## ENGINEERING VARIANCE REQUEST

PROJECT INFORMATION:	
Project Name:	E Sunnyside PRD
Project Number:	PA22-033
Request Submittal Date:	2/23/2023

VARIANCE REQUEST INFORMATION:	
MMC/EDDS Section:	3-219
\$250 Application Fee Submitted:	<input checked="" type="checkbox"/> Yes <input type="checkbox"/> Deferred

NATURAL 9 HOLDINGS, LLC  
**E SUNNYSIDE PRD**  
 COVER SHEET

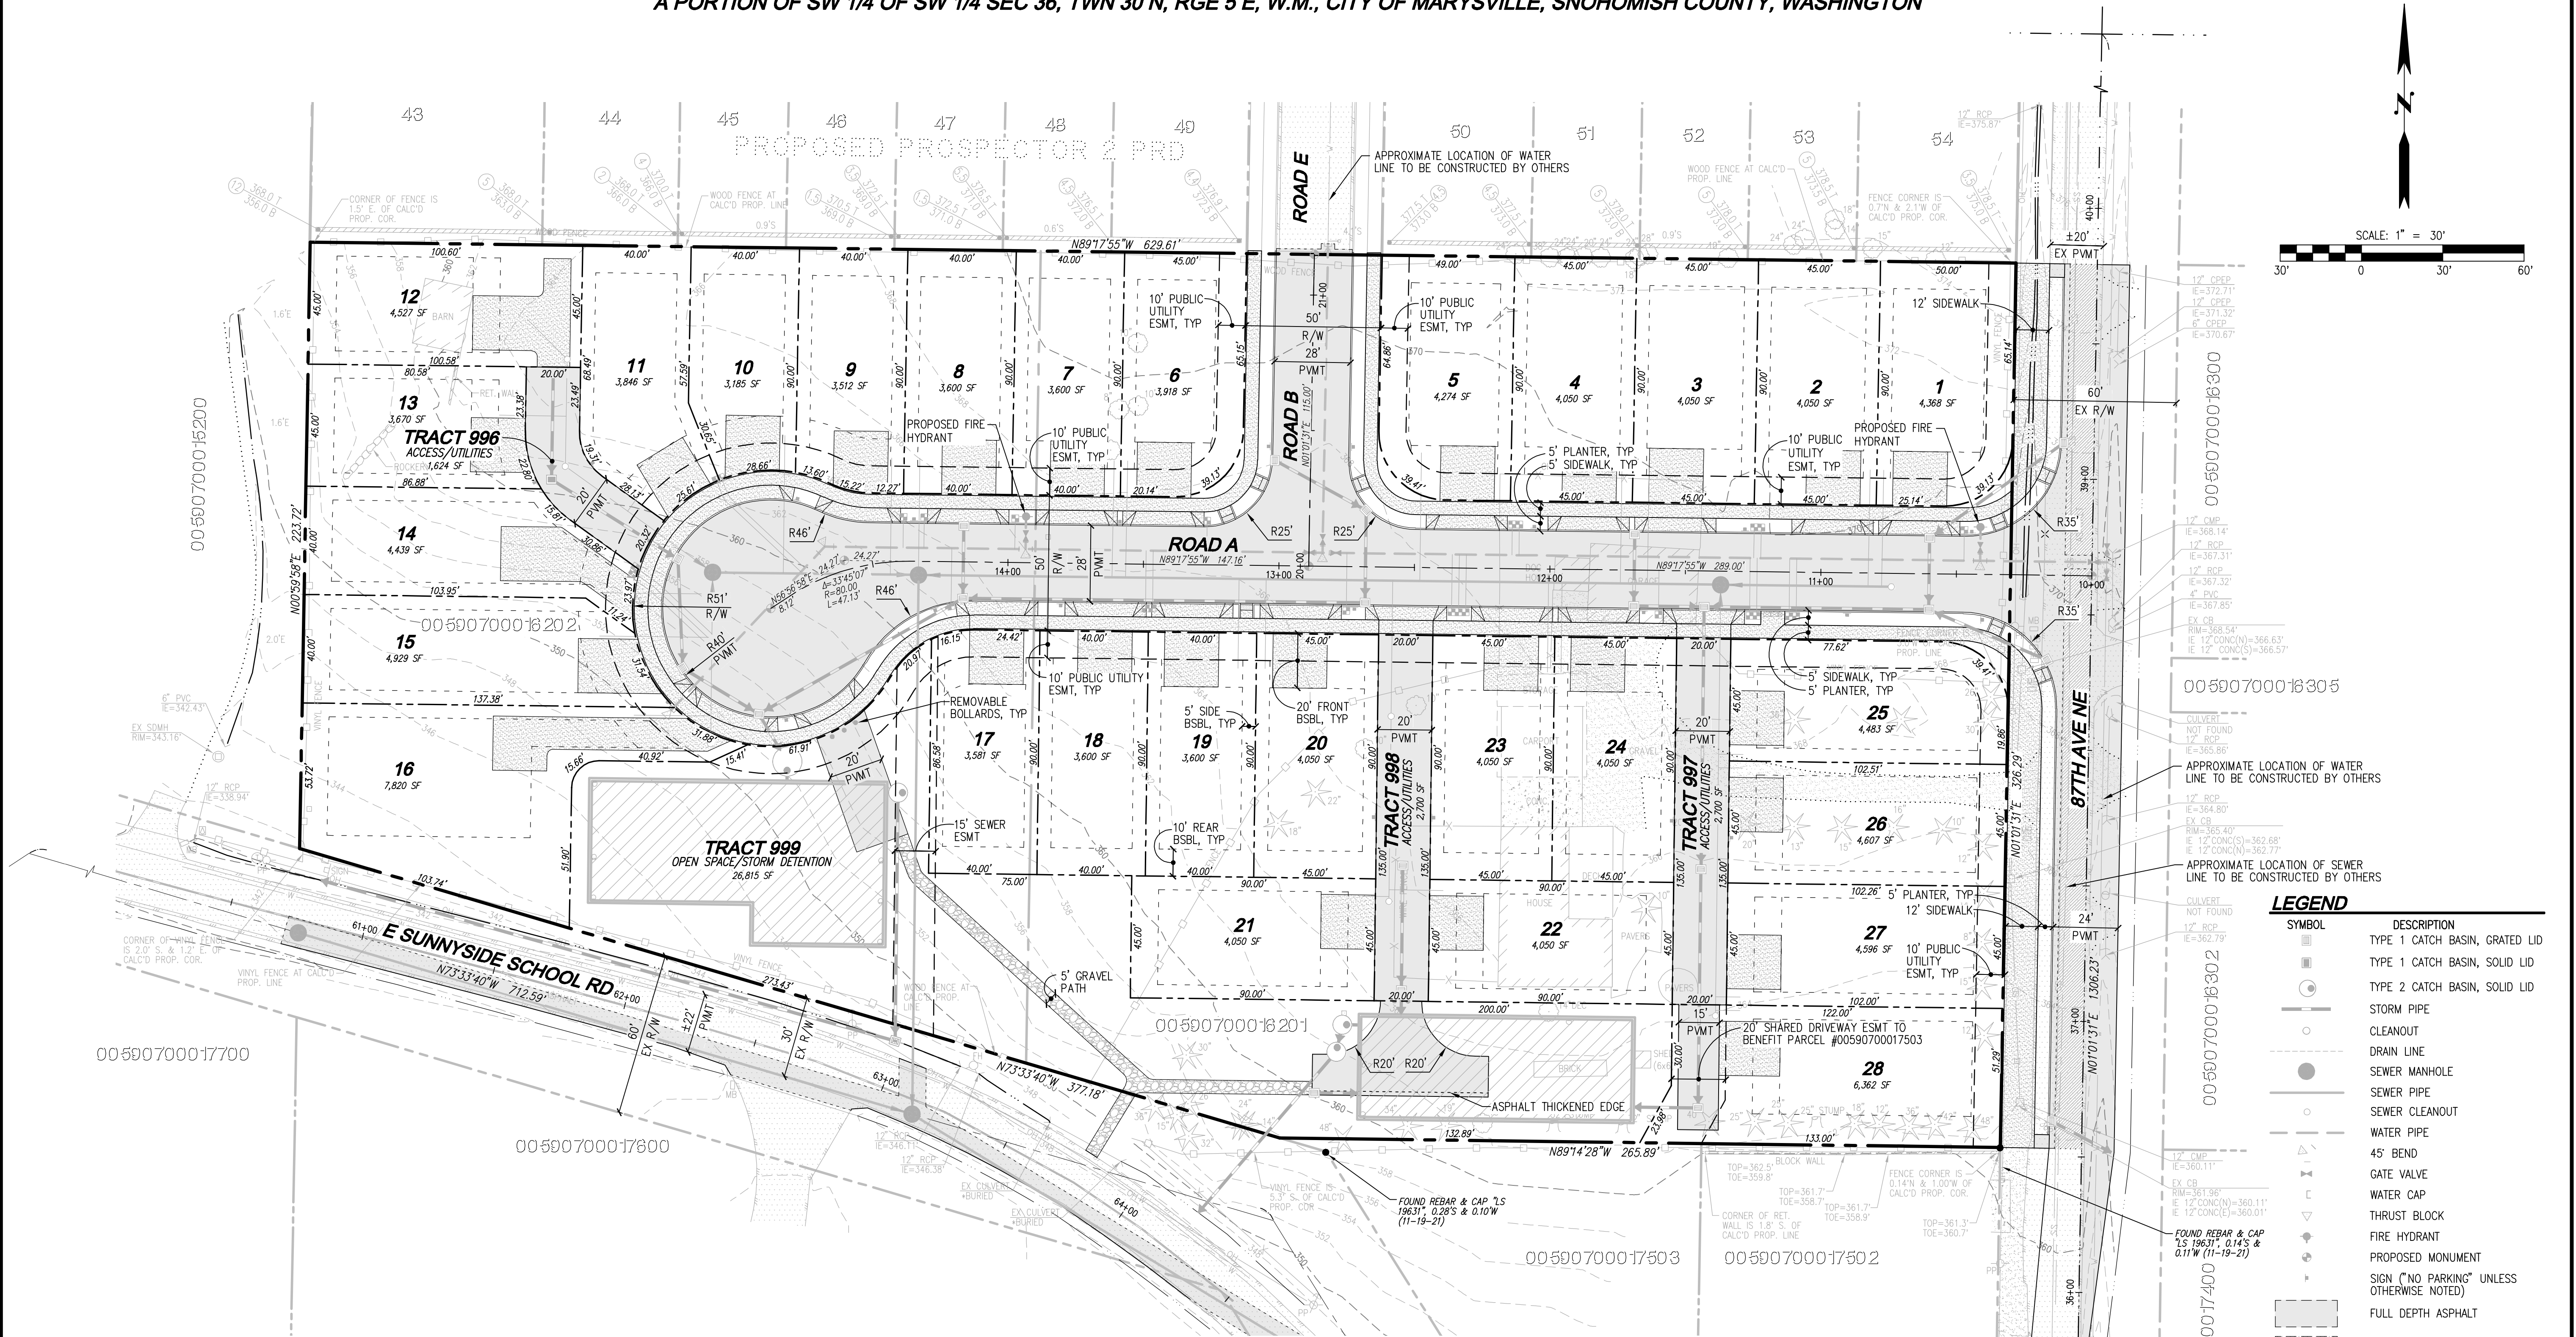
City has requested that the development provide access to the adjacent parcel to the south listed under parcel number 00590700017503. As such, a shared driveway easement will need to be provided through proposed Lot 28. Access to Lot 28 is currently designed through an autocourt stemming from the internal plat road. The resulting in overall length of the combined autocourt and shared access drive to the adjacent parcel to the south exceeds 150' from the proposed plat internal road.

<b>FINDINGS/DECISION</b> <b>(City Staff Use Only)</b>	
<b>Reviewing Staff Member:</b>	Ken McIntyre, PE - Assistant City Engineer
<b>\$250 Application Fee Submitted:</b>	<input type="checkbox"/> Yes <input checked="" type="checkbox"/> Deferred
<b>Decision:</b>	<input type="checkbox"/> Approve <input checked="" type="checkbox"/> Approve with Conditions <input type="checkbox"/> Disapprove
<b><u>Findings/Decision/Conditions:</u></b> <p>The City had previously asked this project to provide vehicular access to Sno Co Tax Lot Number 00590700017503 because the only current vehicular access to that property is via Sunnyside School Road. That portion of Sunnyside School Road is intended to be closed in the future and turned into a public trail or linear park. With that in mind, the City requested this alternate access to ensure the parcel does not become inaccessible.</p> <p>The offsite lot being accessed will not support more than 1-2 homes, so the traffic volumes should be fairly negligible. The Autocourt will exceed the maximum allowed length, but it is in the public interest to ensure that the off-site lot is not left inaccessible. The requested variance is allowed, subject to the following condition:</p> <p>The grading shall be adjusted so that there is no more than a 2-ft grade-differential at the boundary between the project parcel and Tax Lot No. 00590700017503.</p>
